Planning Services Sign Permit Review Form

Date of Submittal	Application Number	Applicant	Landowner
10/09/2020	Sign2010-0004	Lamar Outdoor Advertising	Turnage Lloyd C

Contact Person	Contact Number	Sign Location	PIN Number
Conrad James Plyler	(919) 948-7551	Sadler Rd.	1537-05-5971.000

Reviewed By:	Date of Review	Review Results
Sarah Arbour	10/13/2020	<input type="checkbox"/> Approved <input type="checkbox"/> Denied <input checked="" type="checkbox"/> More information required

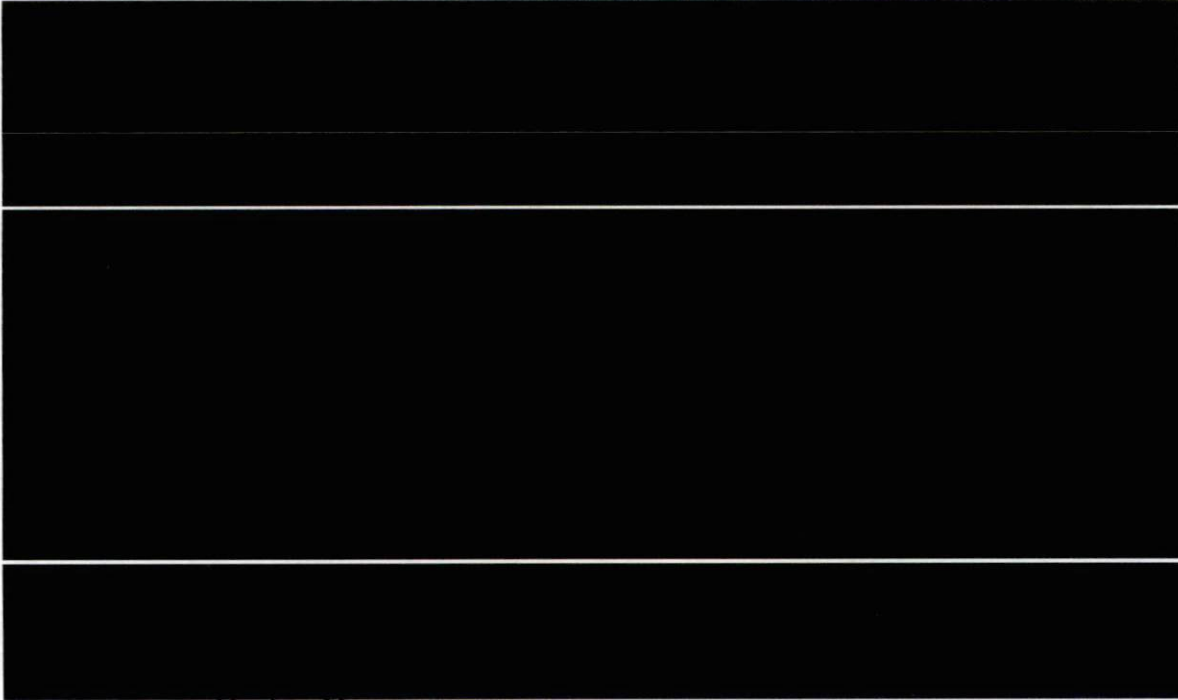
Comments	<p>Please provide the following information:</p> <ol style="list-style-type: none"> 1. Please provide the NCDOT License # 2. A site plan that indicates the distance from the new location of the billboard and the new ROW after the expansion of I-95 is required. 3. Is does the scope of work include relocation only, or complete reconstruction of the outdoor advertising signs? The site plan indicates it was removed, but going in the same location.
----------	---
